Location of Construction: 16 STORER ST	Owner Name: WAYNFLETE SCHOOL THE	Owner Address: 256 SPRING ST REAR	Phone:
Business Name:	Contractor Name: Stroudwater Construction	Contractor Address: 96 Ocean St unit 1 Portland	Phone 2076507802
Lessee/Buyer's Name	Phone:	Permit Type: Educational	Zone:

Wednesday afternoon, November 14, 2007
Waynflete Arts Center Phase Two

11/24/2007-ldobson: I'm nearly complete with the review of the project and have some questions:

Thanks,
Mike Nugent
Consulting Plans Examiner
City of Portland

2 AUDITORIUM SECTION
 SCALE: 1/4" = 1'-0"

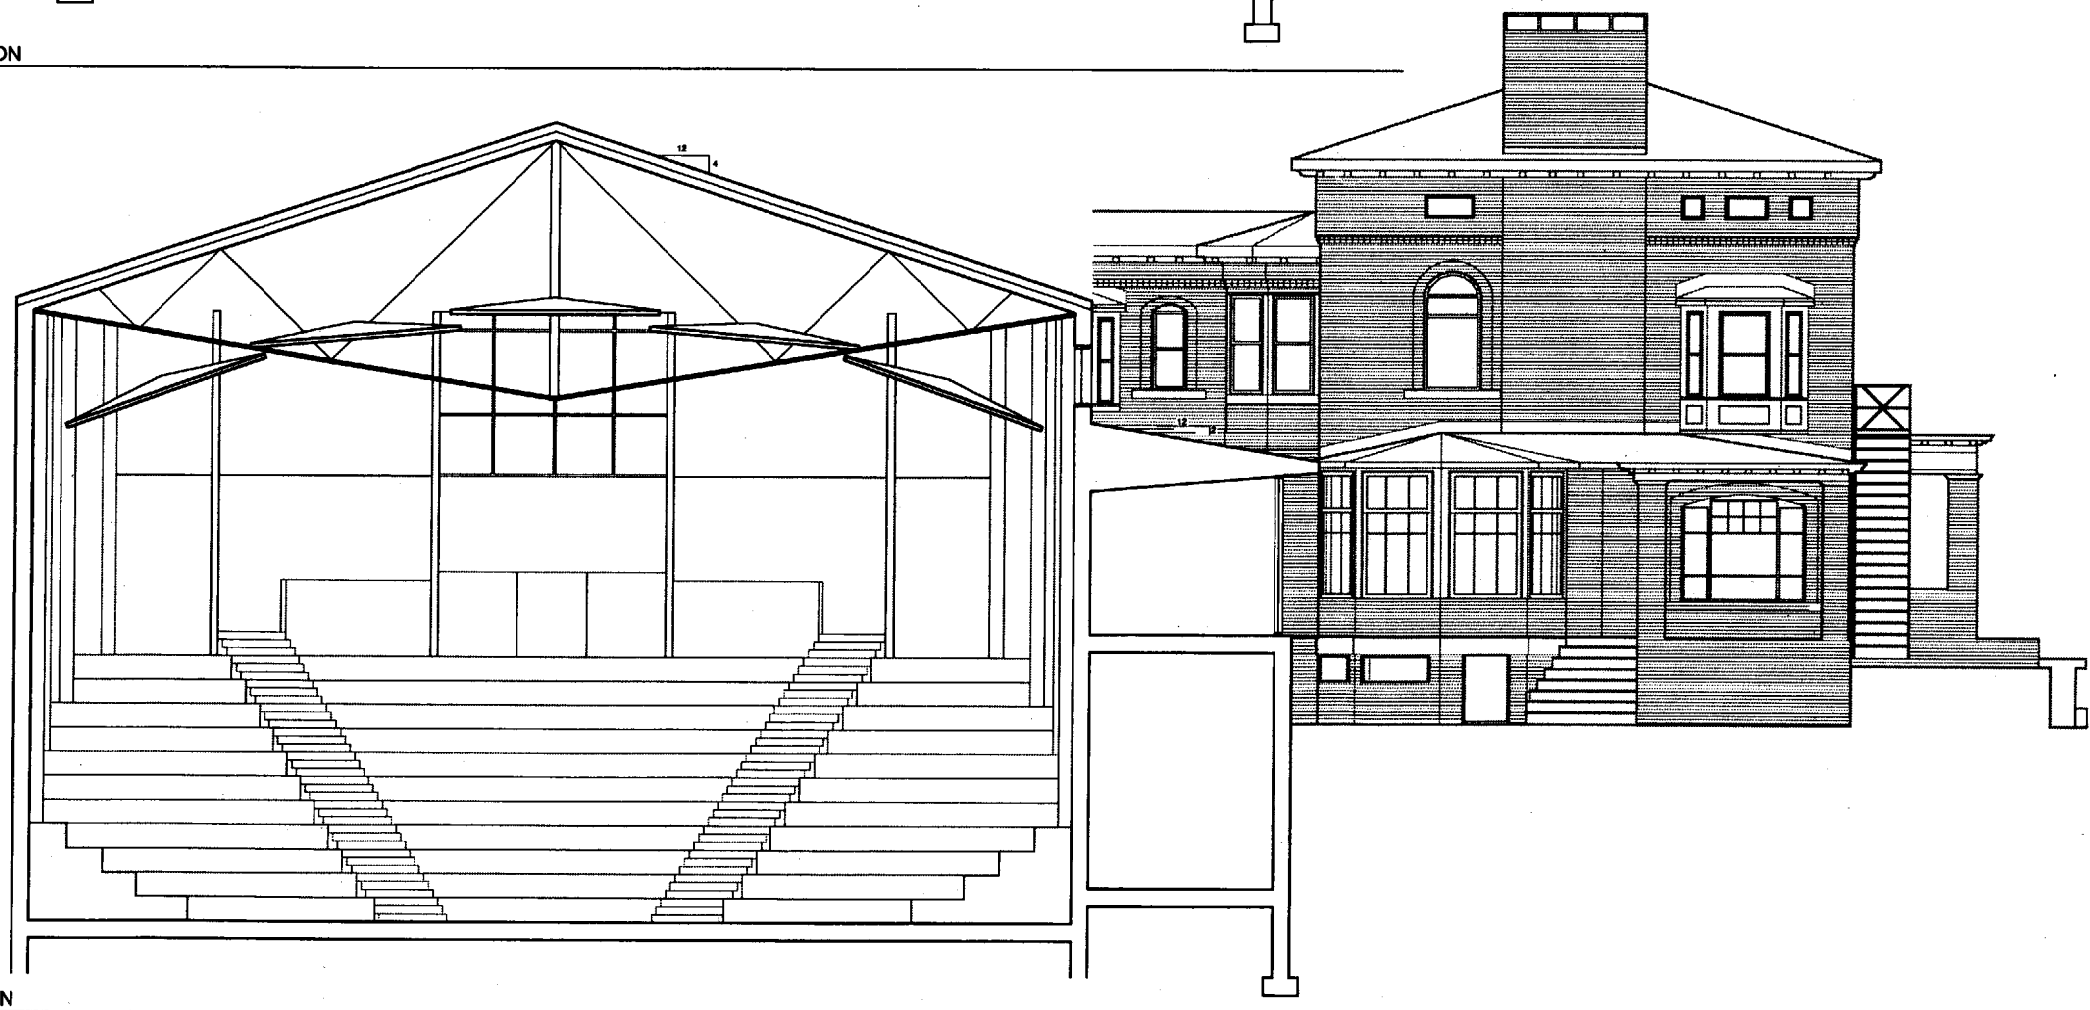
- 7) Please provide a guard detail for the guard shown on the lower right corner on fig. 2/A-3.2.
- 8) Please provide a Plumbing fixture number assessment for the existing and proposed occupant load that establishes compliance with the State Plumbing Code (based on the 2000 UPC)

Drawing file: PDF071184 / A-1.2 FIRST FLOOR PLAN.pdf

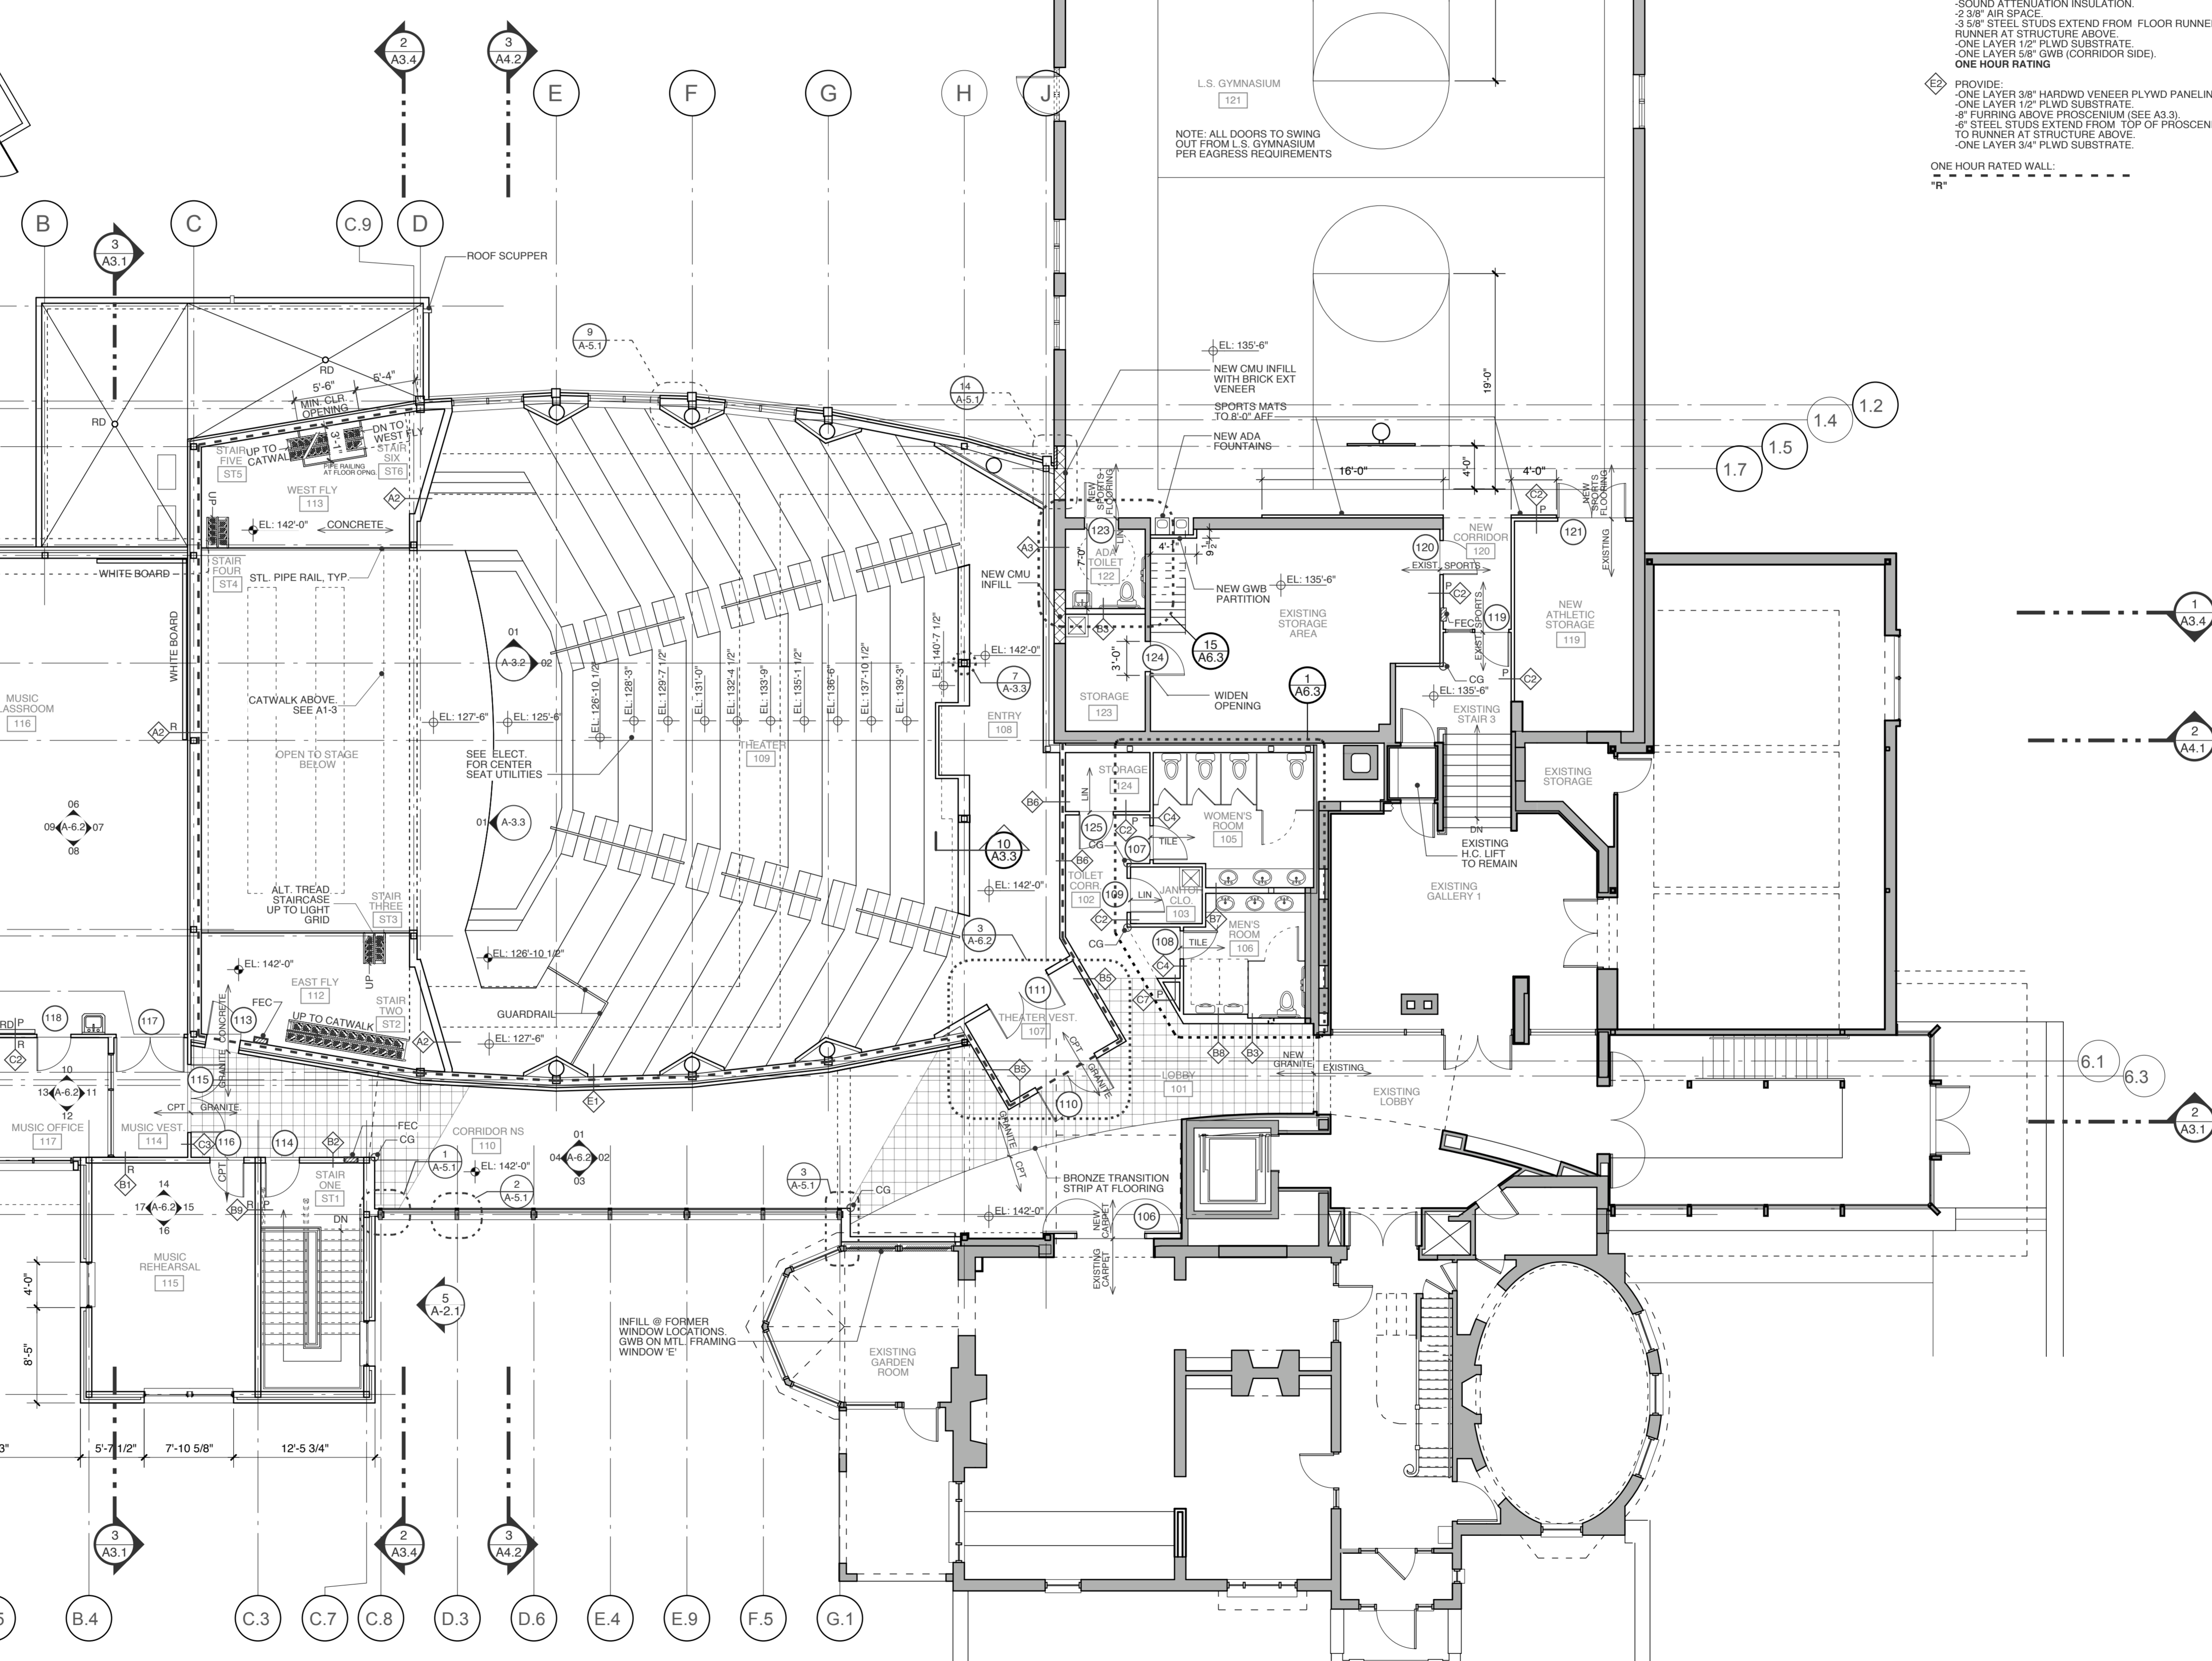
- 2) On the First floor plan view on page A-1.2, it appears that the only means of egress from this space is into the theater vestibule. I know I'm missing something, please explain. I see a second double door on fig. 1/ A-3.2. Just want to make sure I have it right! With regard to overall occupant load, and because we are relying on existing egress components, Please provide a life safety plan that summarizes total occupant load of the entire area (existing and proposed) and all of the elements of egress, with their dimensions. Please review Section 1024.2 and provide compliance information. (Main Exit Requirements)
